**St Matthews Catholic College (SSD-9872)
Response to Submissions**

The Department has also undertaken a preliminary assessment of the EIS and, in addition to the issues raised in submissions, requires the matters at **Attachment 1** be addressed in full. You are requested to provide the Department with a response to the submissions as soon as possible.

DRAWING TITLE  
**FLOOD MITIGATION WORKS**

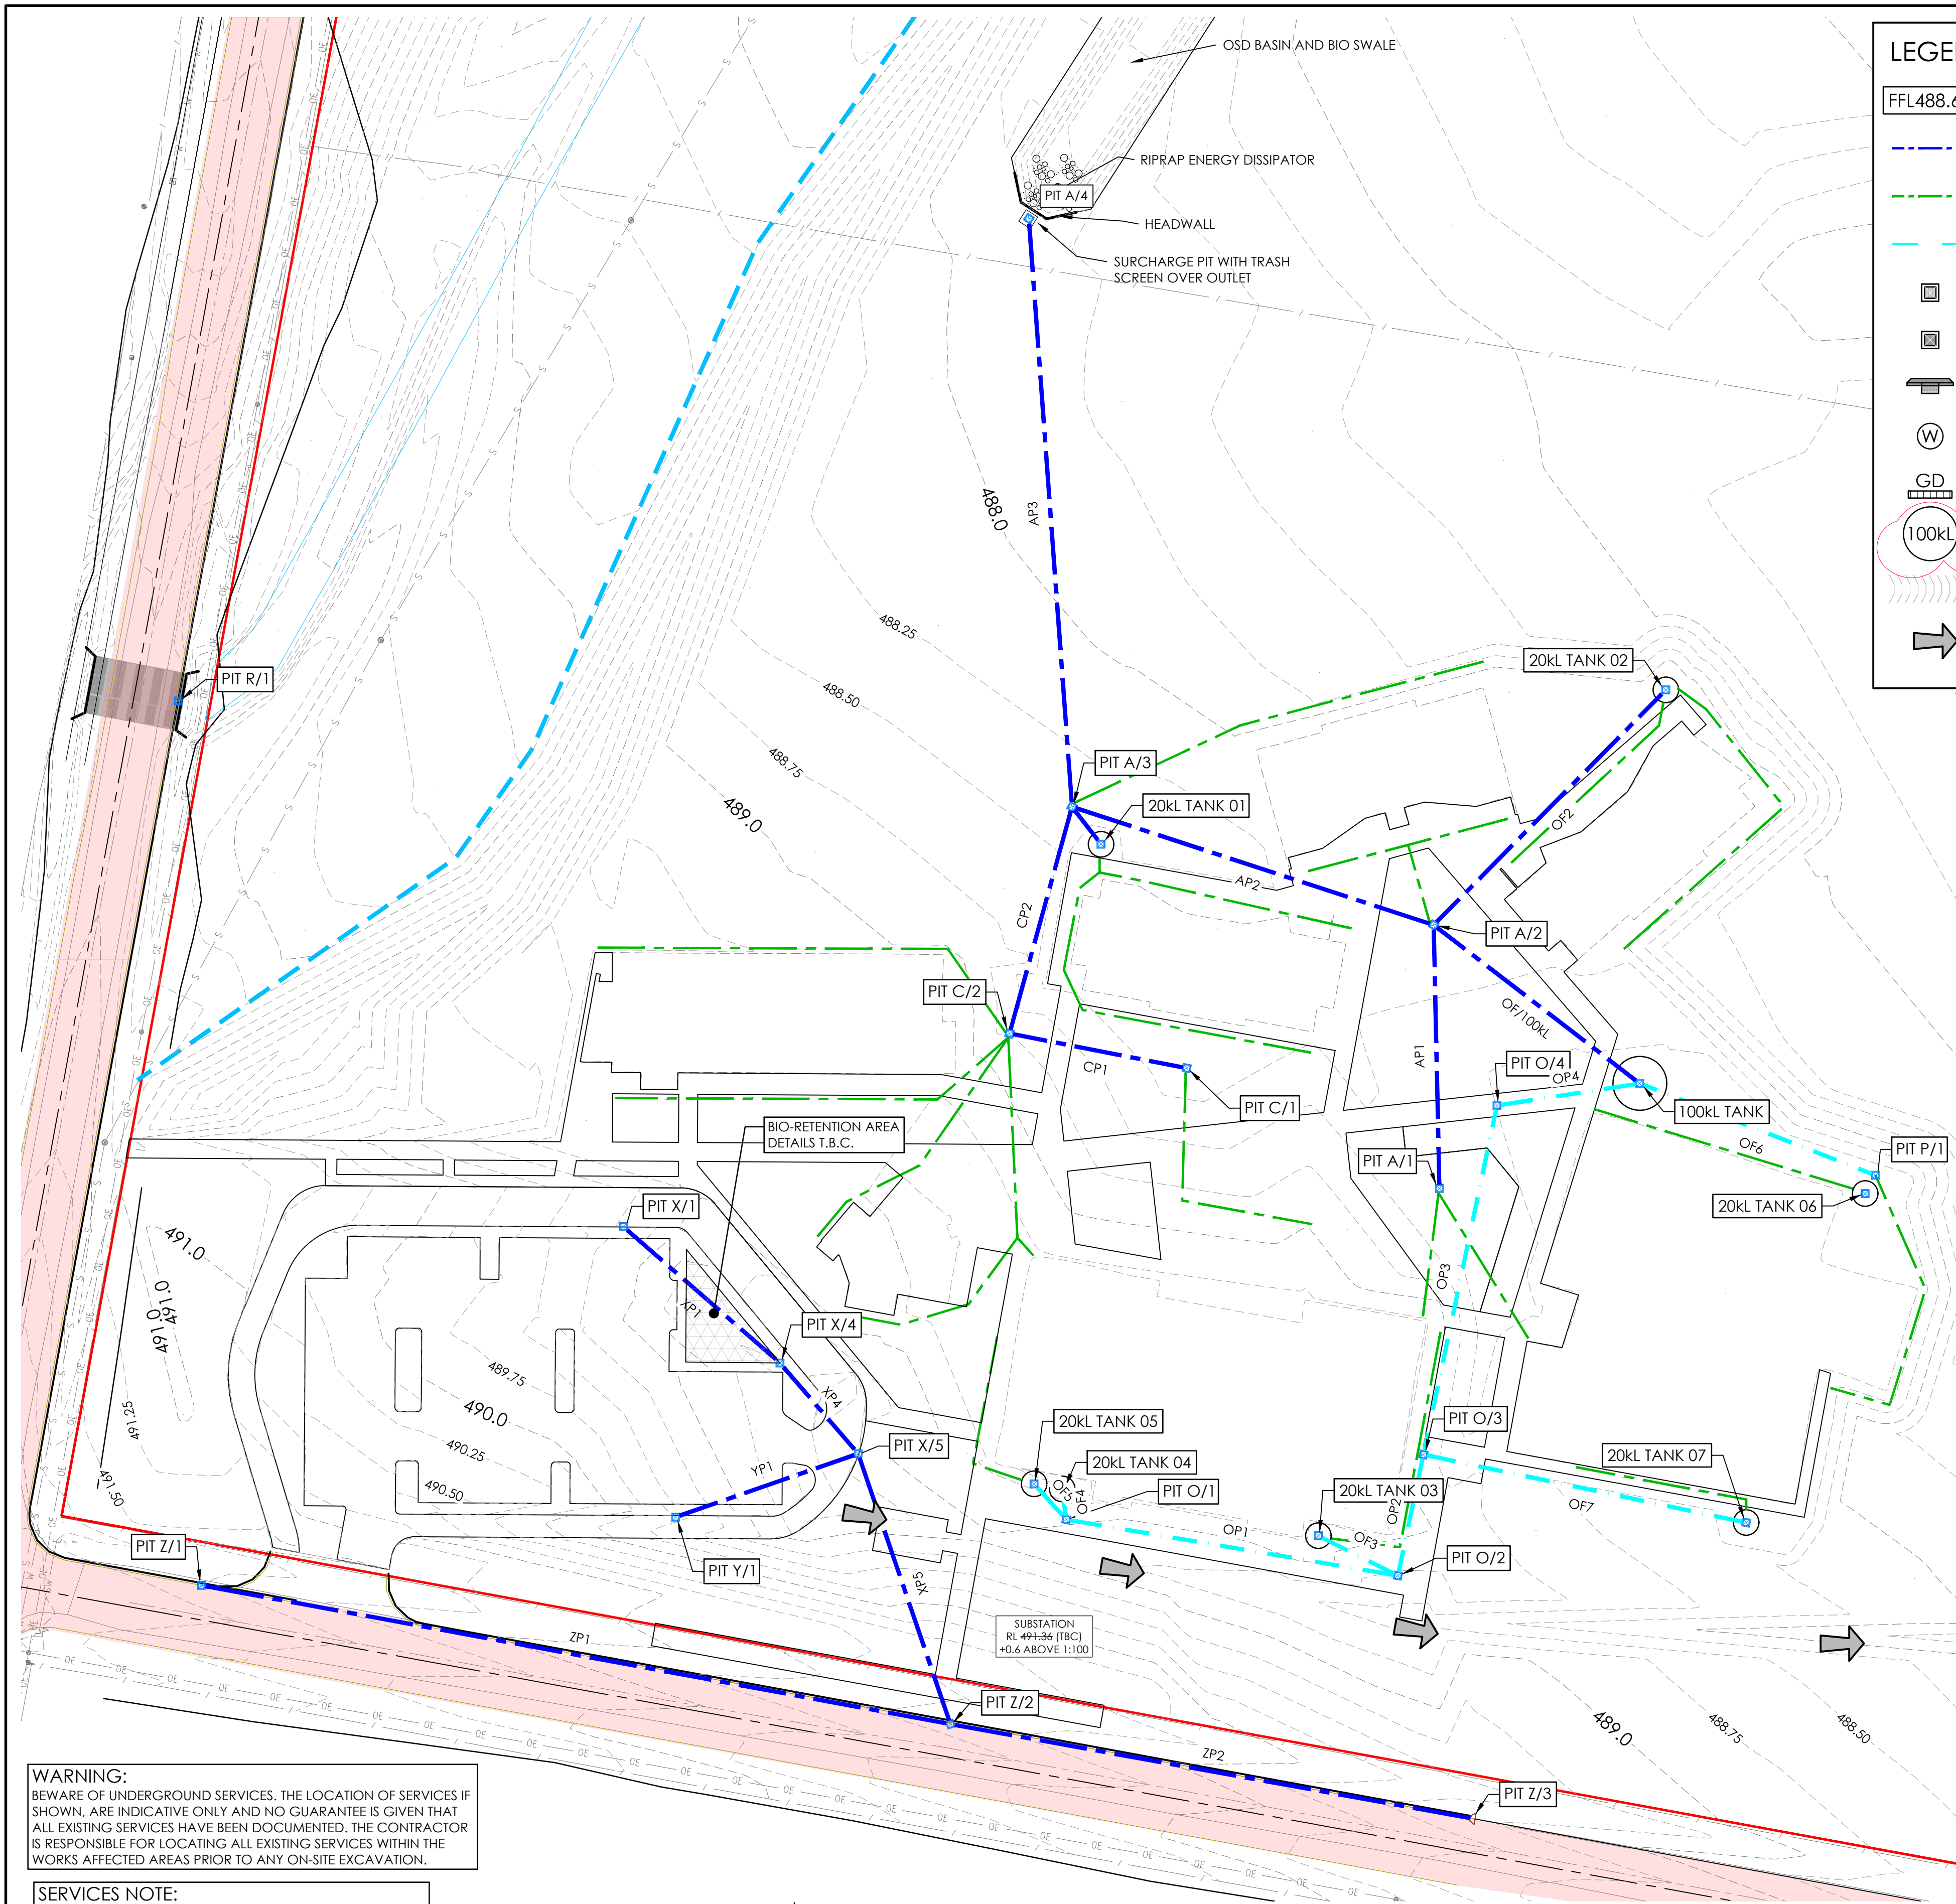
- The site is located within a natural catchment known as “Sawpit Gully” and is therefore impacted by a flood hazard. In accordance with Council’s comment, a detailed Stormwater Drainage and Management Plan is to be submitted for the development.
- The stormwater management plan must assess the impacts on the downstream properties and include details of a lawful point of discharge for the development. The Department notes that a drainage easement along the defined water course may be required in the absence of any pre-existing discharge point or changes to the

DRAWING TITLE  
STORMWATER MANAGEMENT  
PLAN

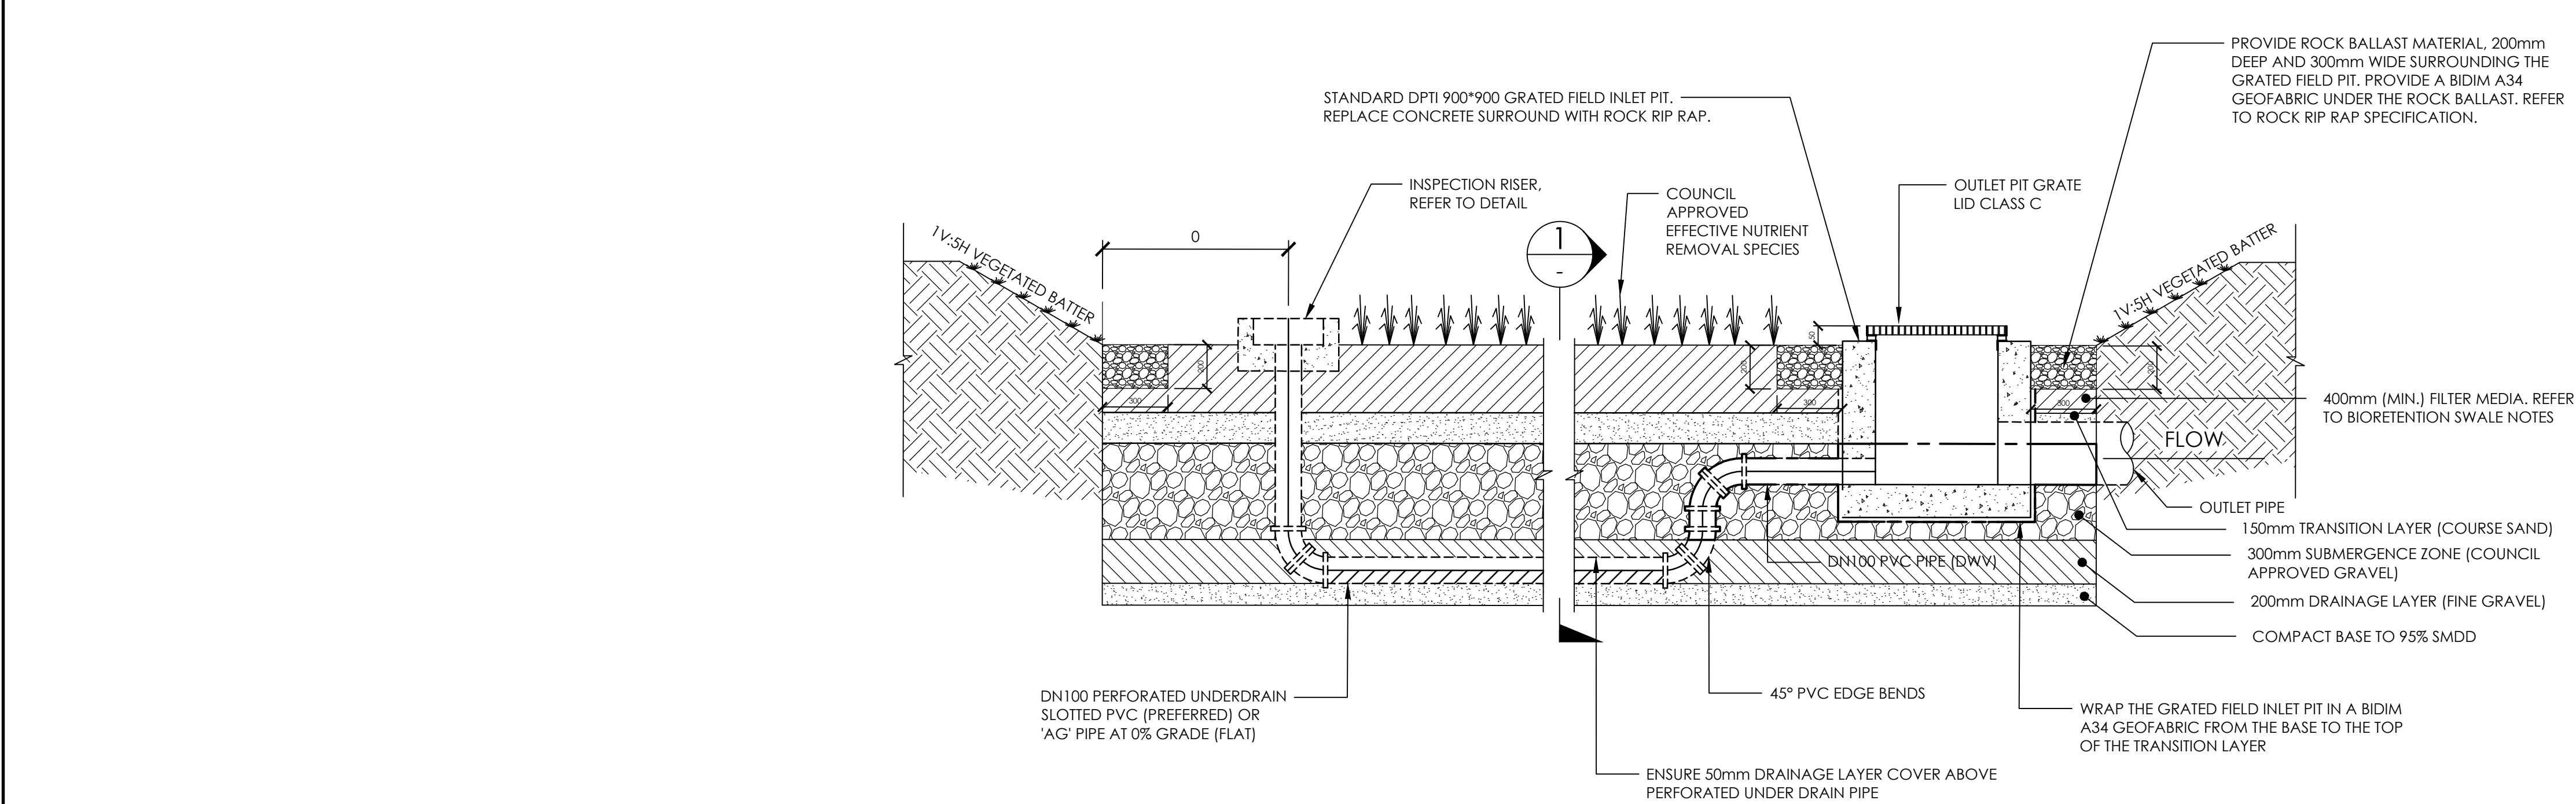
stormwater flow concentration / regime due to the proposed development on the site. The matters in relation to the requirement of a drainage easement is required to be clarified in the RTS.
